**RE: College of Fine Arts (COFA) Redevelopment - MP 08_0104
University of New South Wales, Paddington Campus**

Section 75W Modification – Block D

This amendment seeks to modify minor aspects of the approved Block D. The consent is to be amended to refer to a new set of plans for Block D, prepared by Architectus, titled “UNSW-COFA Gateway” dated July 2010, being Drawing Nos:

project	COFA Gateway
drawing	SITE PLAN WITH SHADOW DIAGRAMS
drawing no.	issue
A0-02	C

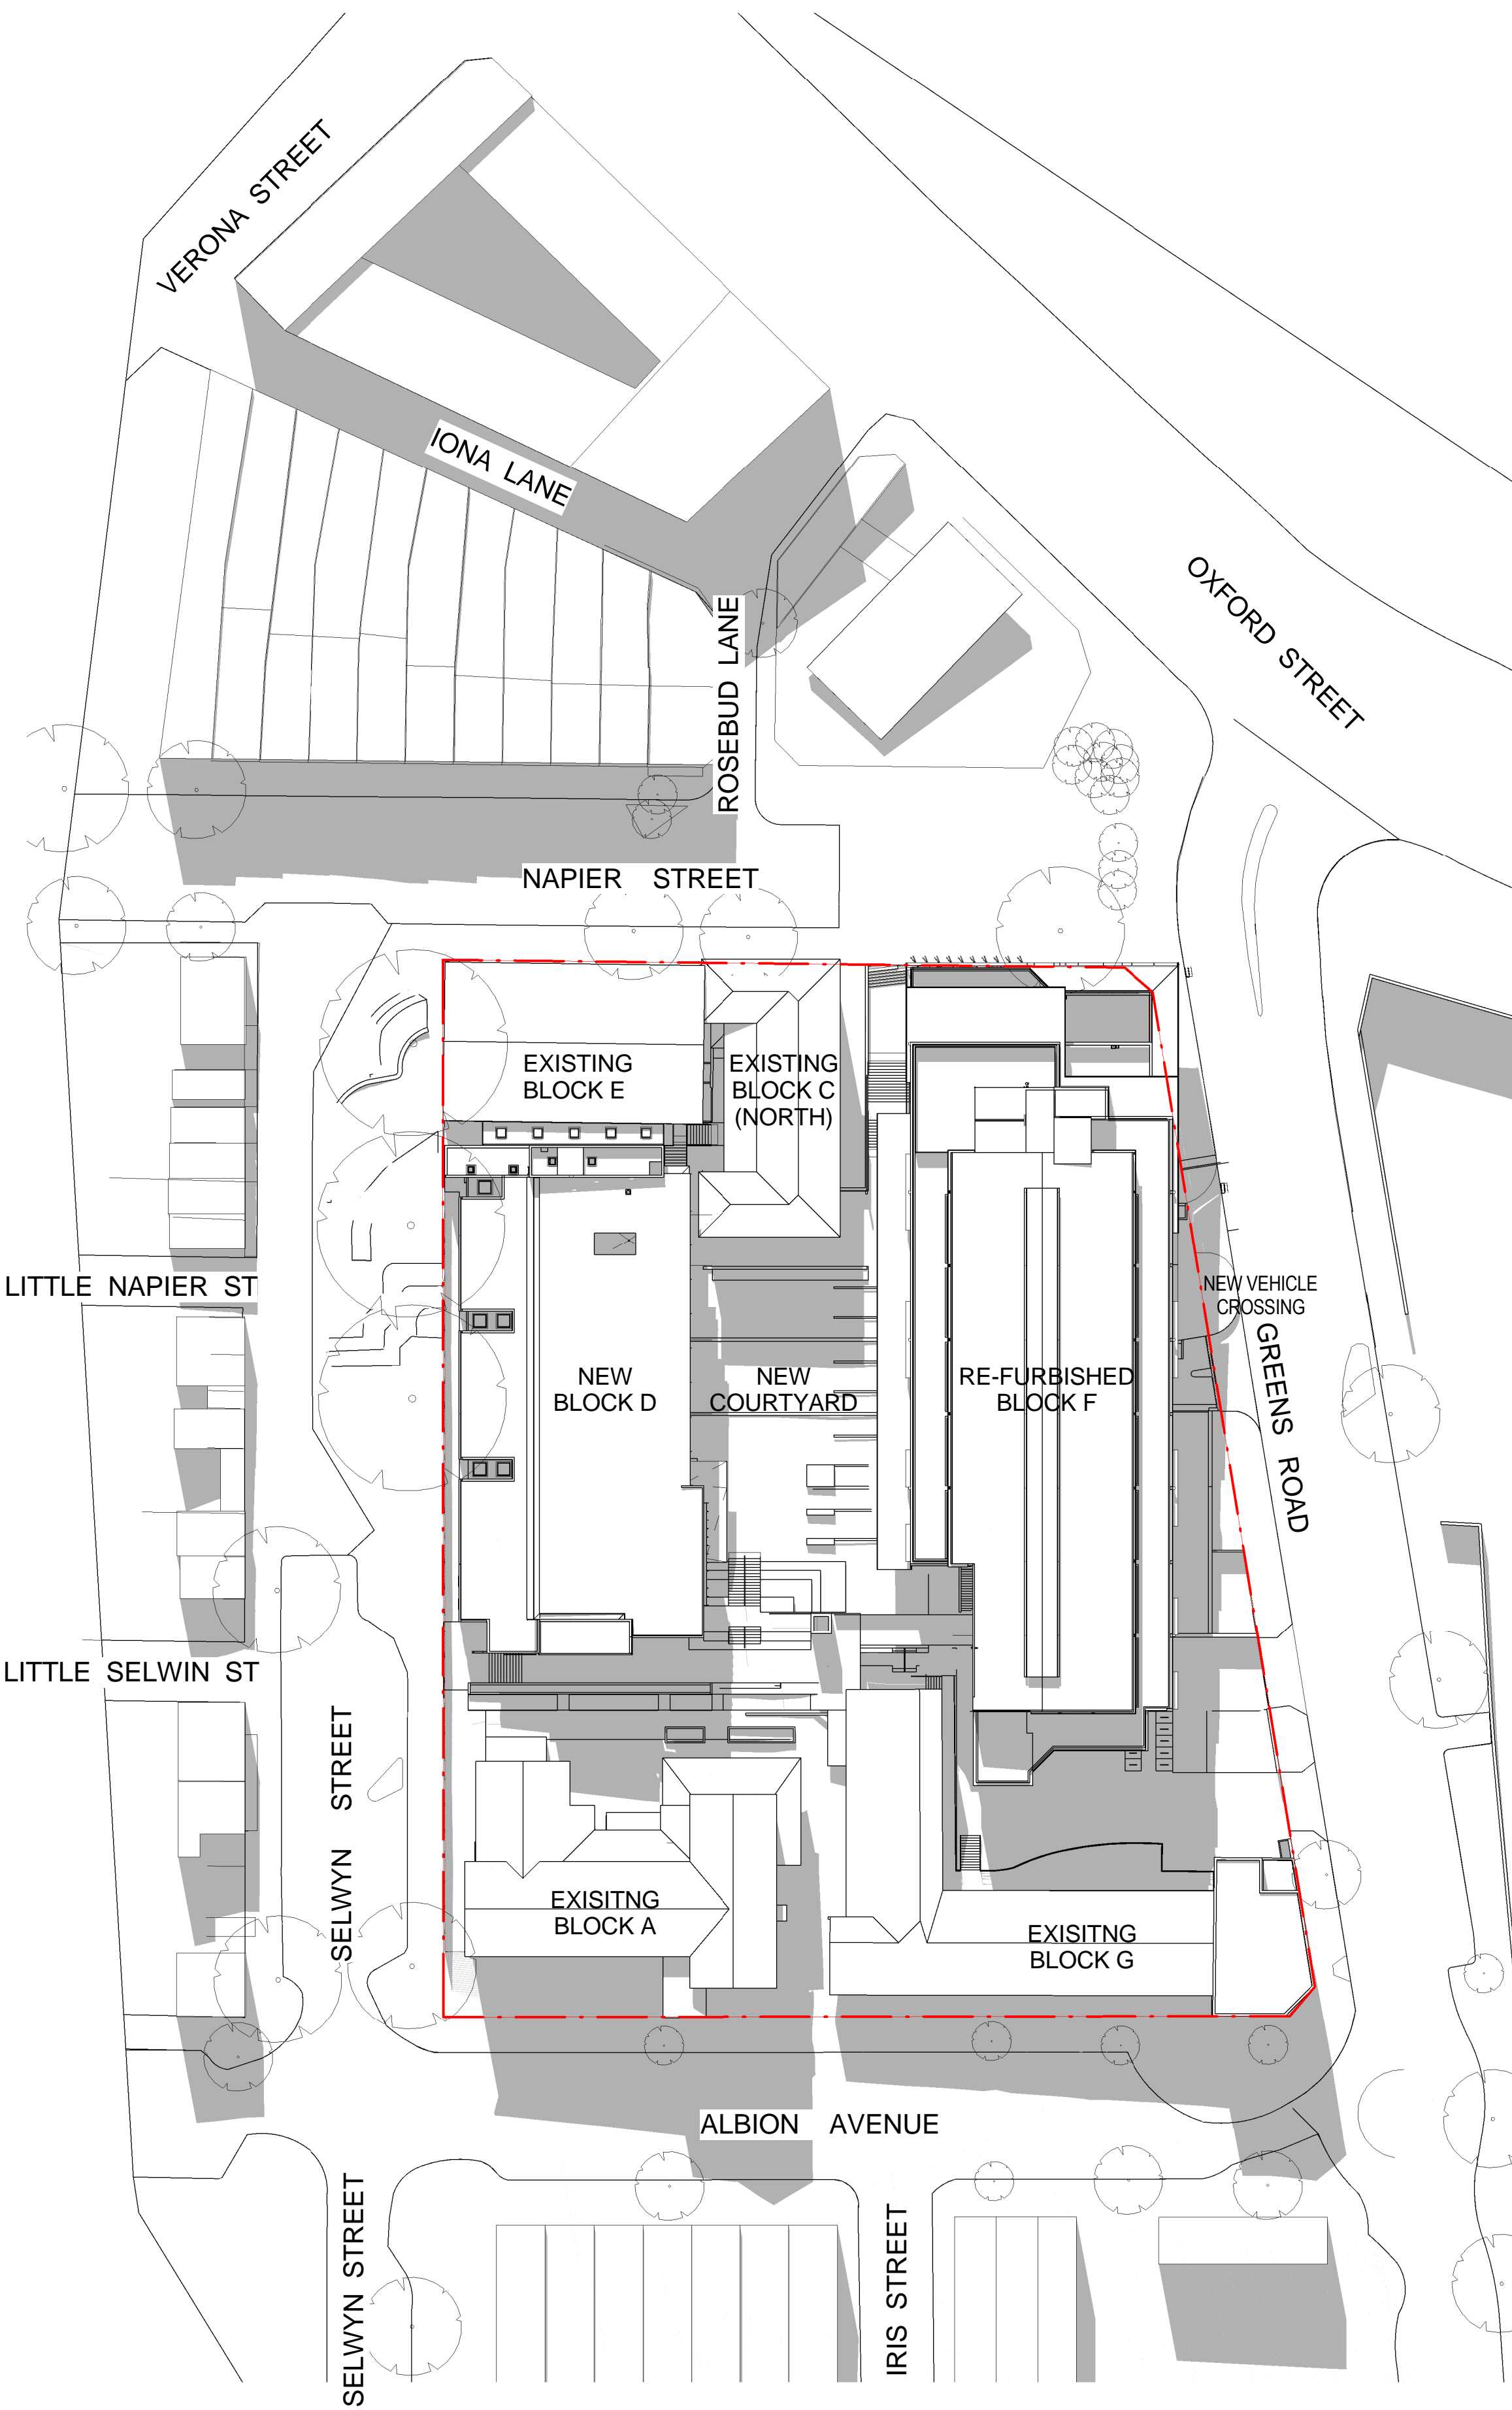
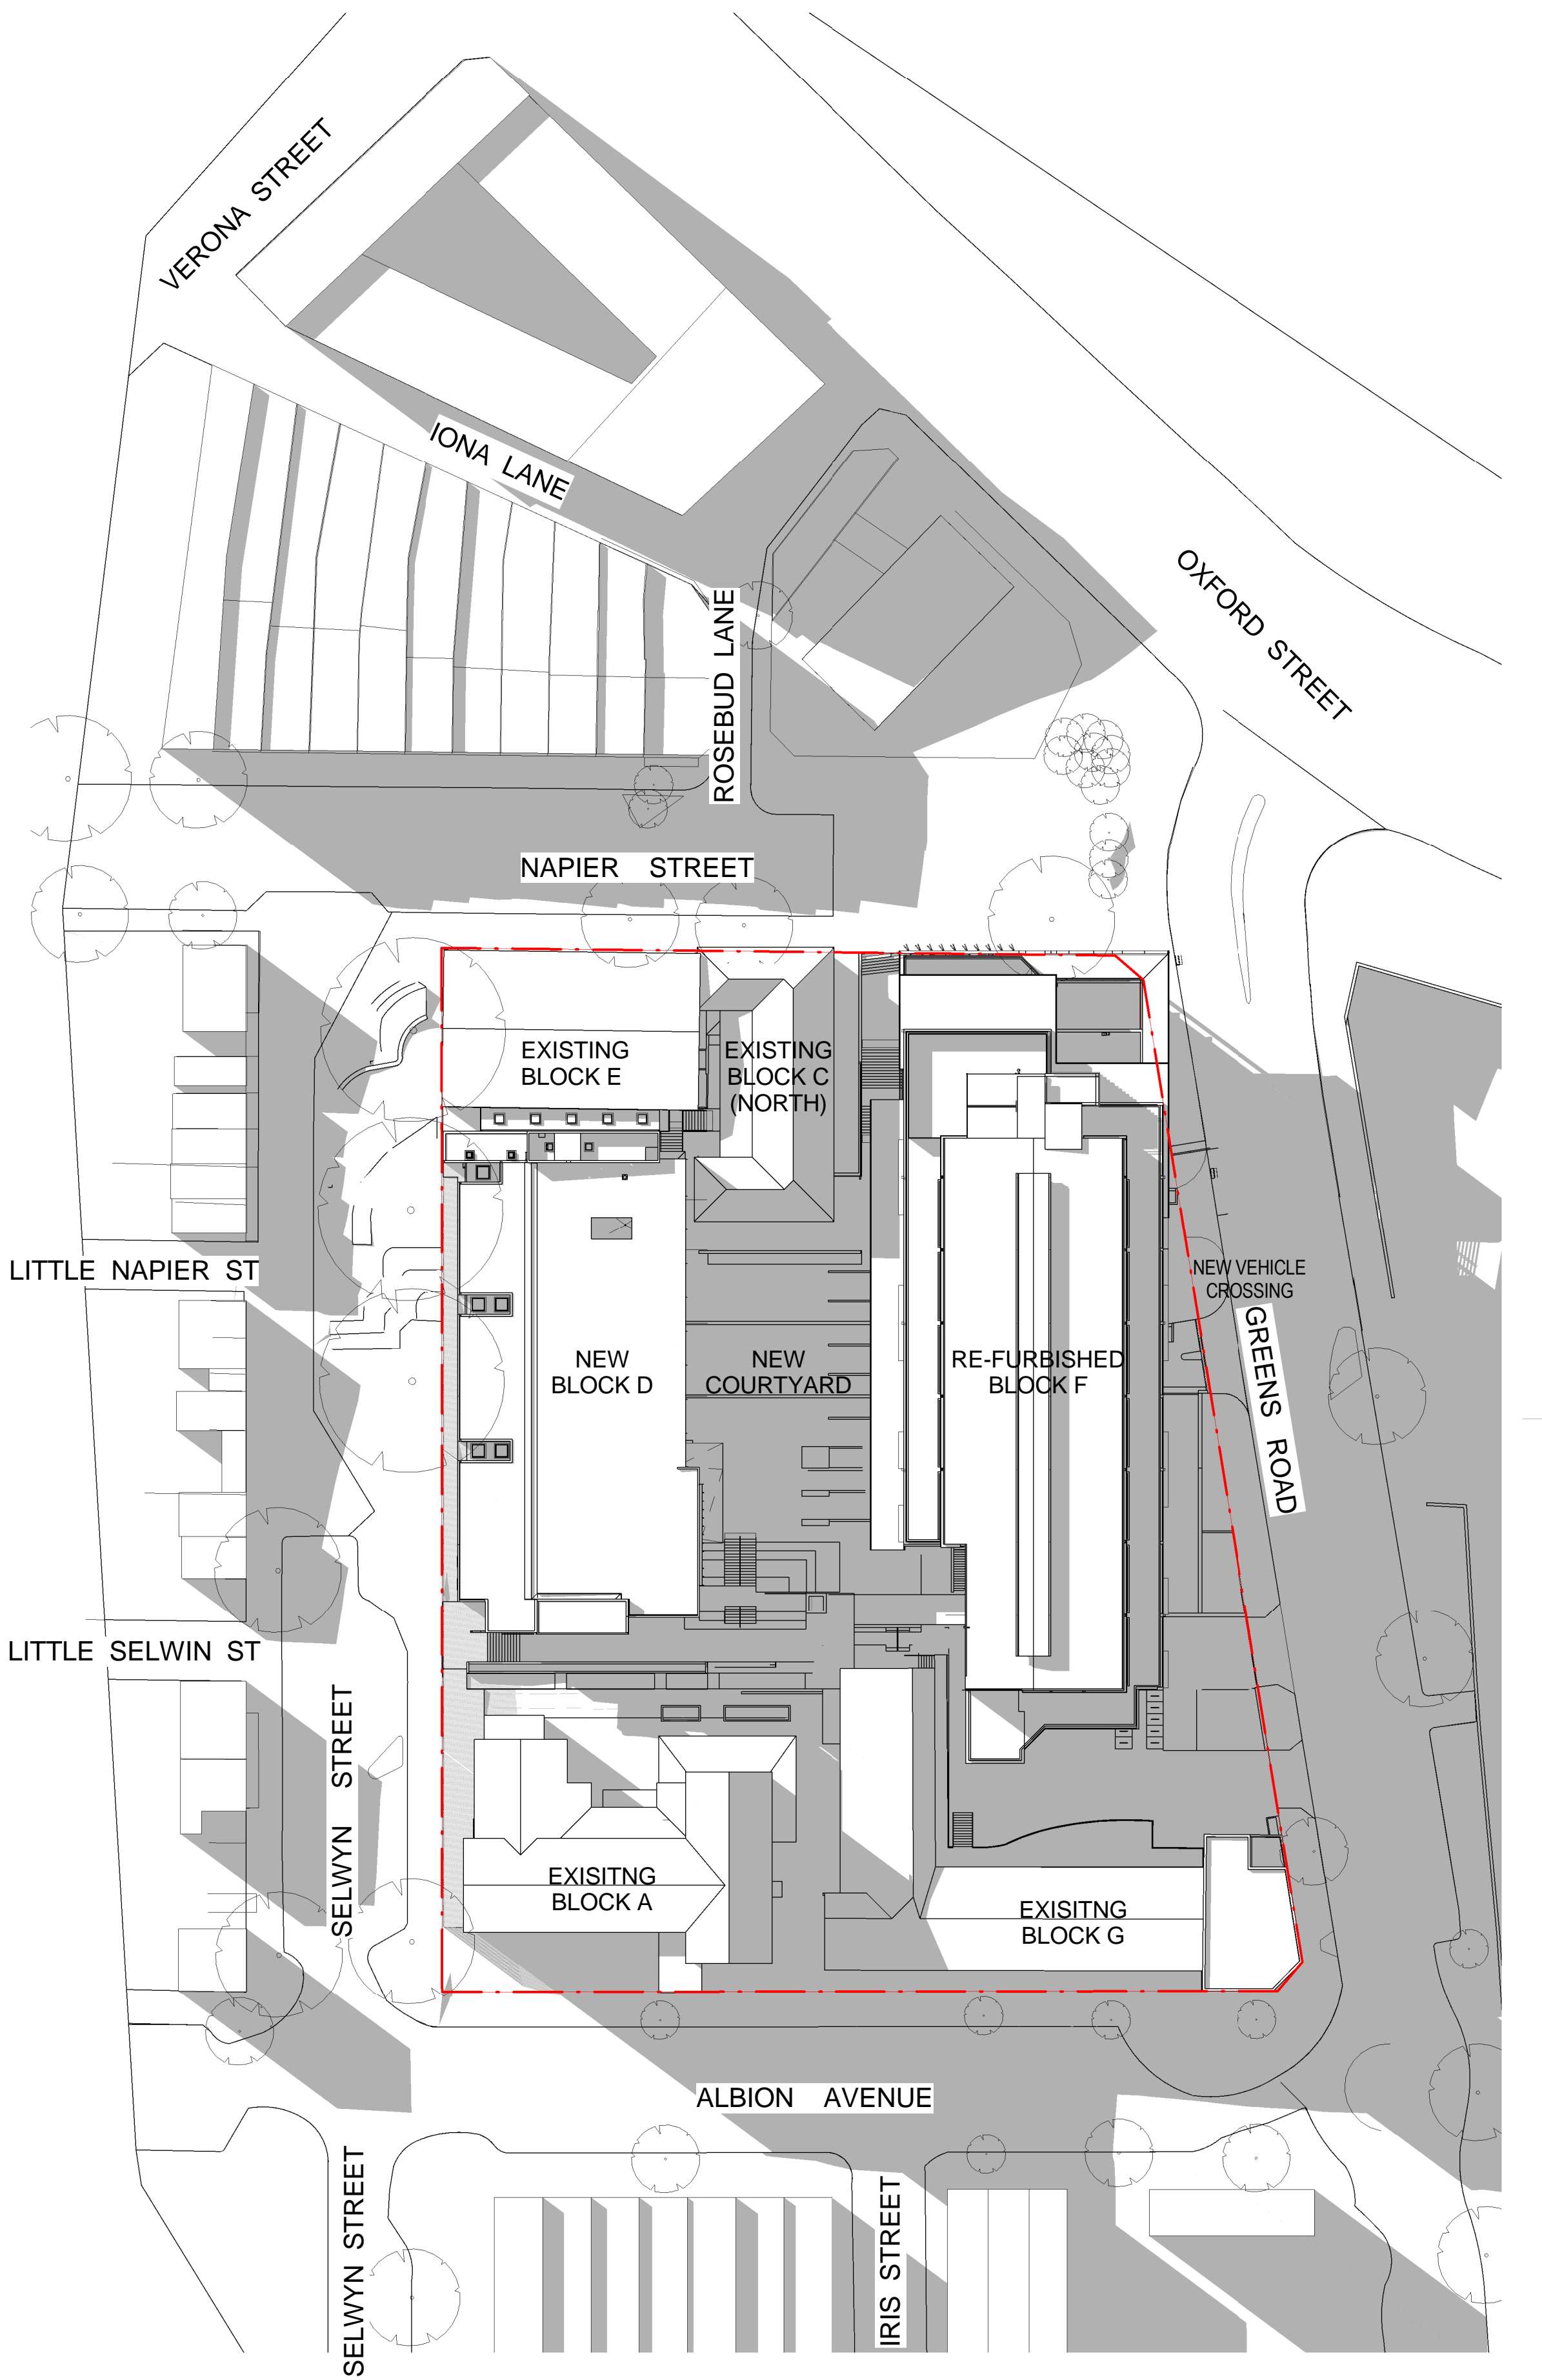
Approved Dwg No	Amended Dwg No	Element	Proposed Modifications	Reason for Modifications	Impact of Modifications
A0-01 B	A0-01 C	Drawing List Site Plans	Revised to reflect Block D changes.	Drawing consistency.	Nil.
A0-02 B	A0-02 C	Shadow Diagrams	Revised to reflect Block D changes.	Drawing consistency.	Shadow impact on Selwyn Street marginally decreased.
A1-01 B	A1-01 C	Overall Plan – Basement (Formerly Level 1)	<ul style="list-style-type: none"> Block D relocated 1630mm to east away from Selwyn Street boundary. Gridlines adjusted to reflect new position. Lightwells omitted from Basement. Internal fit-out for plant and education uses. 	<ul style="list-style-type: none"> Response to arborist advice. Increased setback alters set-out lines. Proposed use of basement precludes need for daylight. Internal space allocations and fit-out now proposed. 	<p>Increased protection for trees; decreased shadow impact.</p> <p>Nil.</p> <p>Nil</p>
